Application no: 19/00616/OUT-3

Location: OS Parcel 9507 South Of 26 And Adjoining Fewcott Road Fritwell

Lead Local Flood Authority

Officer's Name: Adam Littler
Officer's Title: Drainage Engineer
Date: 04 December 2019

### **Proposed Outline Surface Water Drainage Strategy**

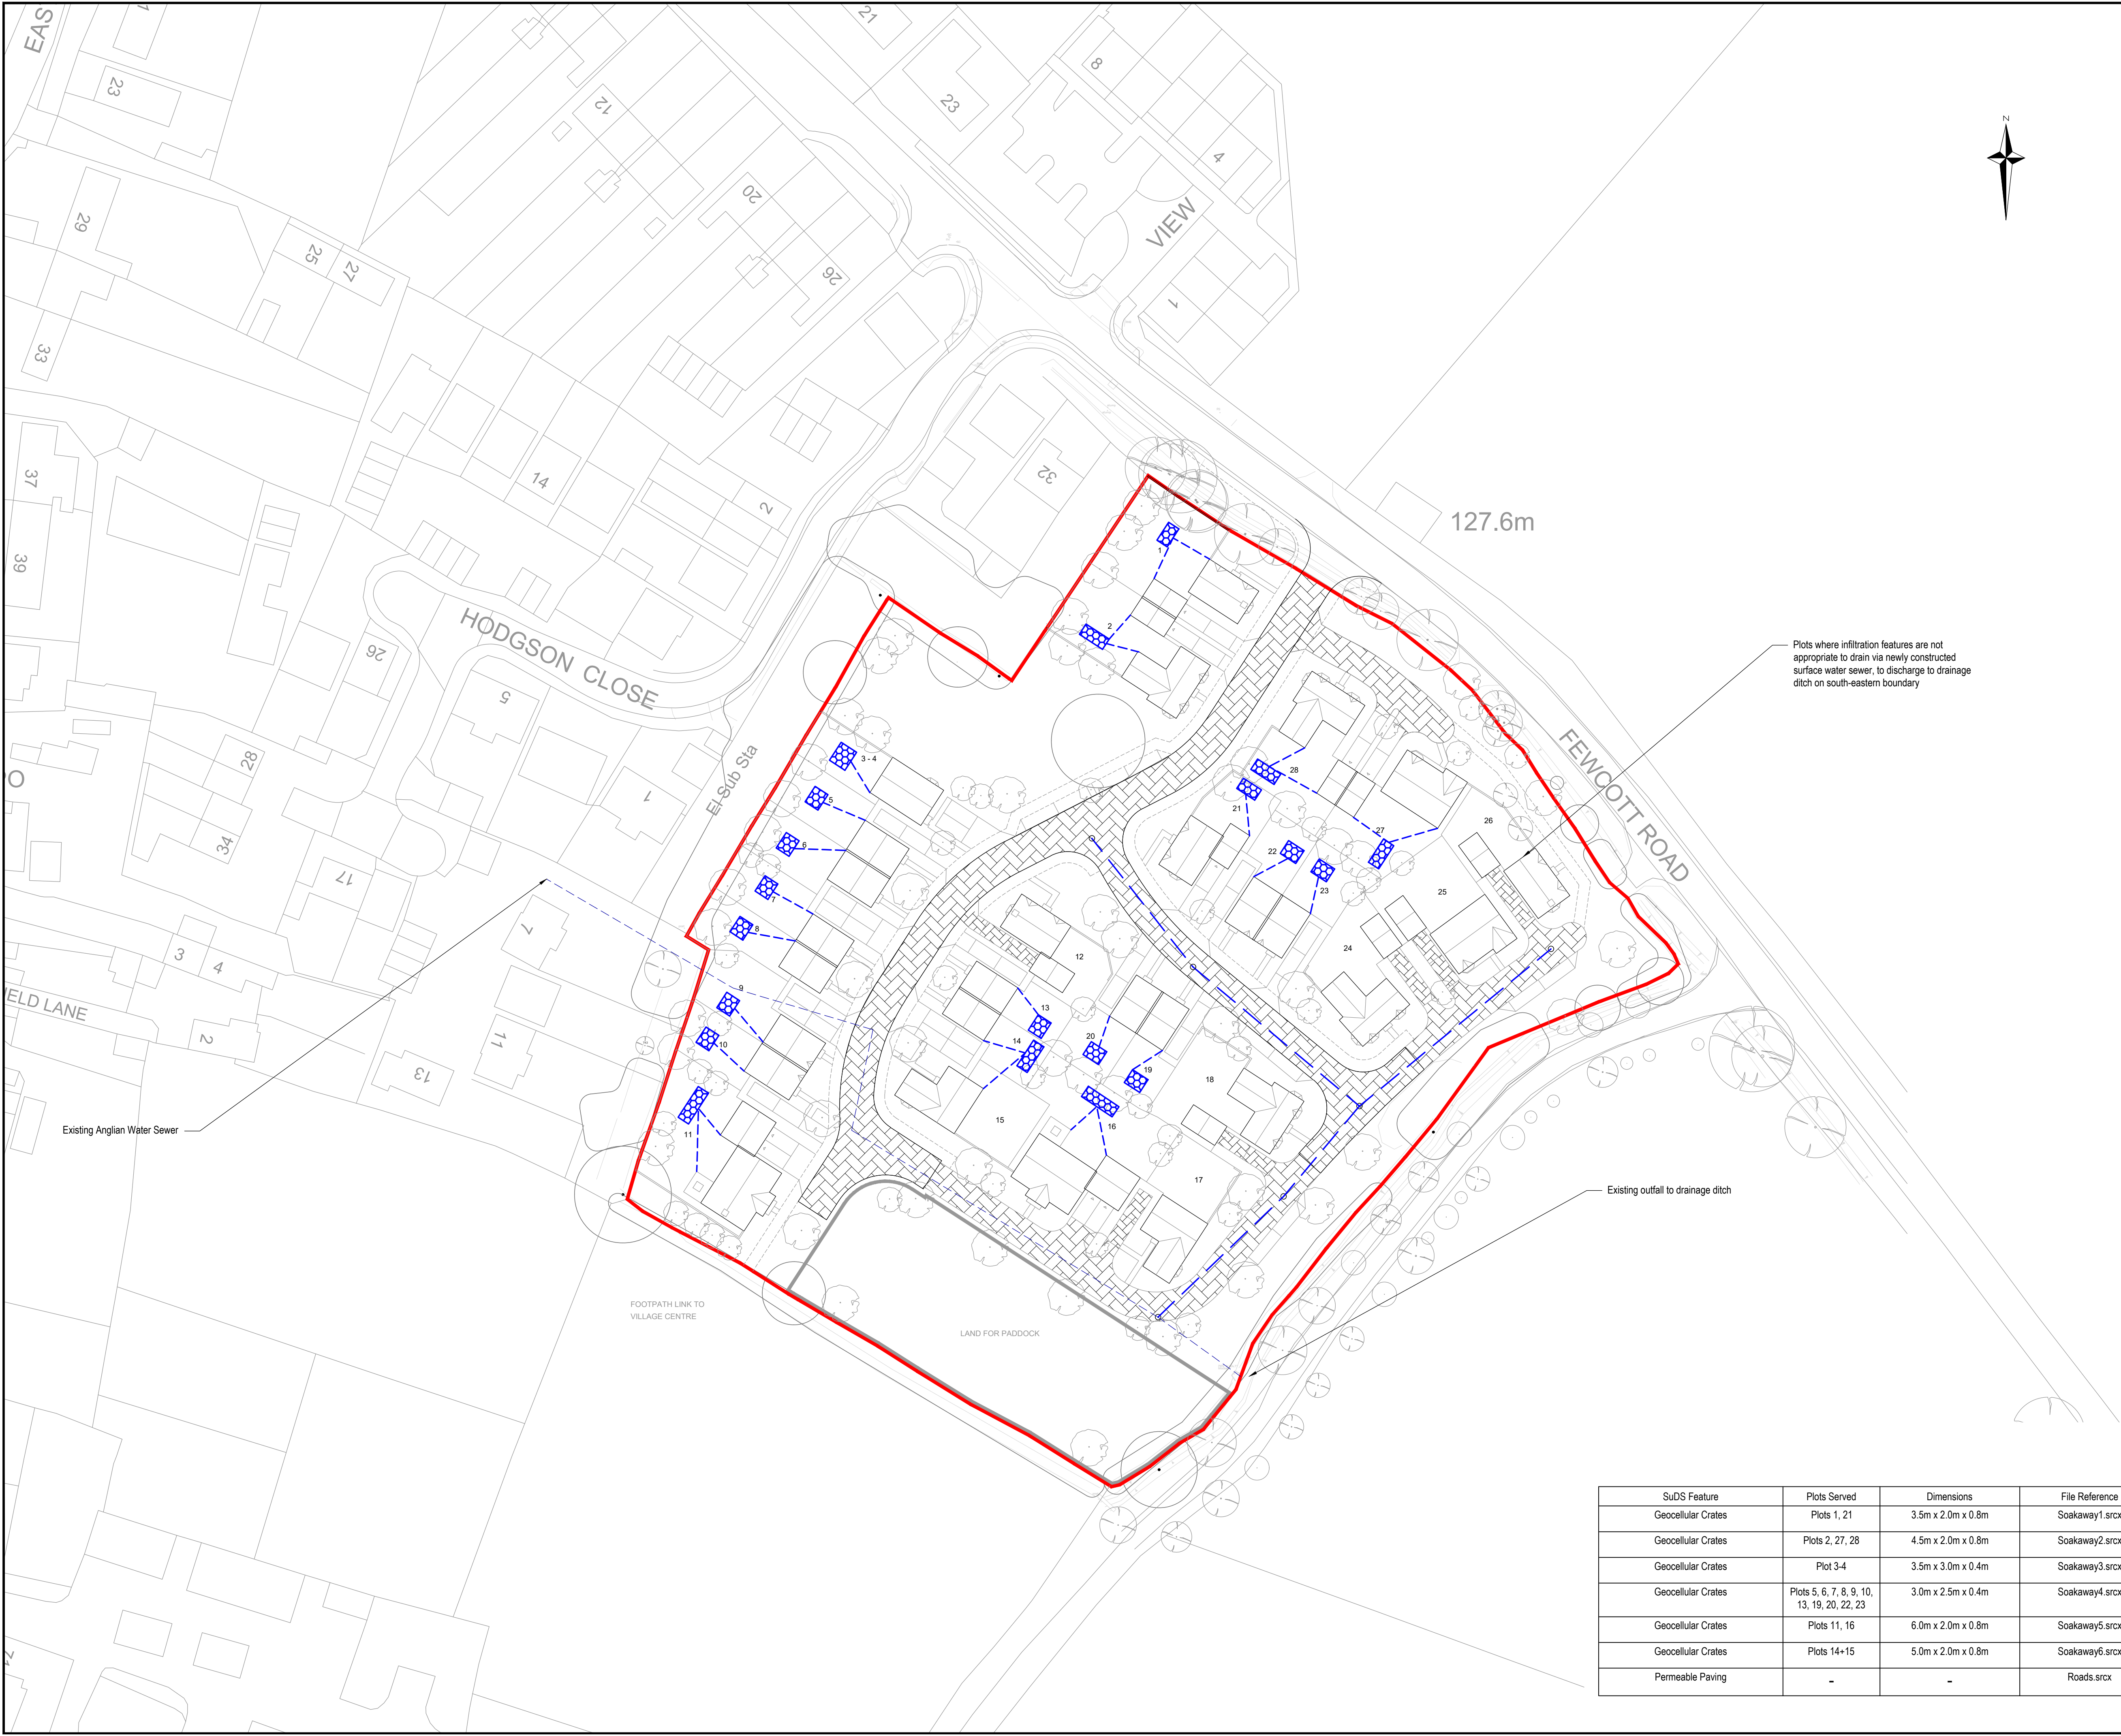
- Discharge at relevant return periods to be at Greenfield rate.
- 40% Climate Change allowance to be applied to calculations.
- MicroDrainage calculations provided use default Cv values, these are not representative of the site. It is recommended values of 0.95 for roofs and 0.9 for paved areas are applied. The designer must justify where a Cv of less than 0.9 has been used.
- Evidence of Source Control required.
- Water to be kept at or as close to the surface as possible.
- Sacrificial areas in the event of exceedance should be considered.
- Further thought needs to be given to maximising use of green space on site for
- SuDS incorporation.
- Treatment and Management train needs to be demonstrated.
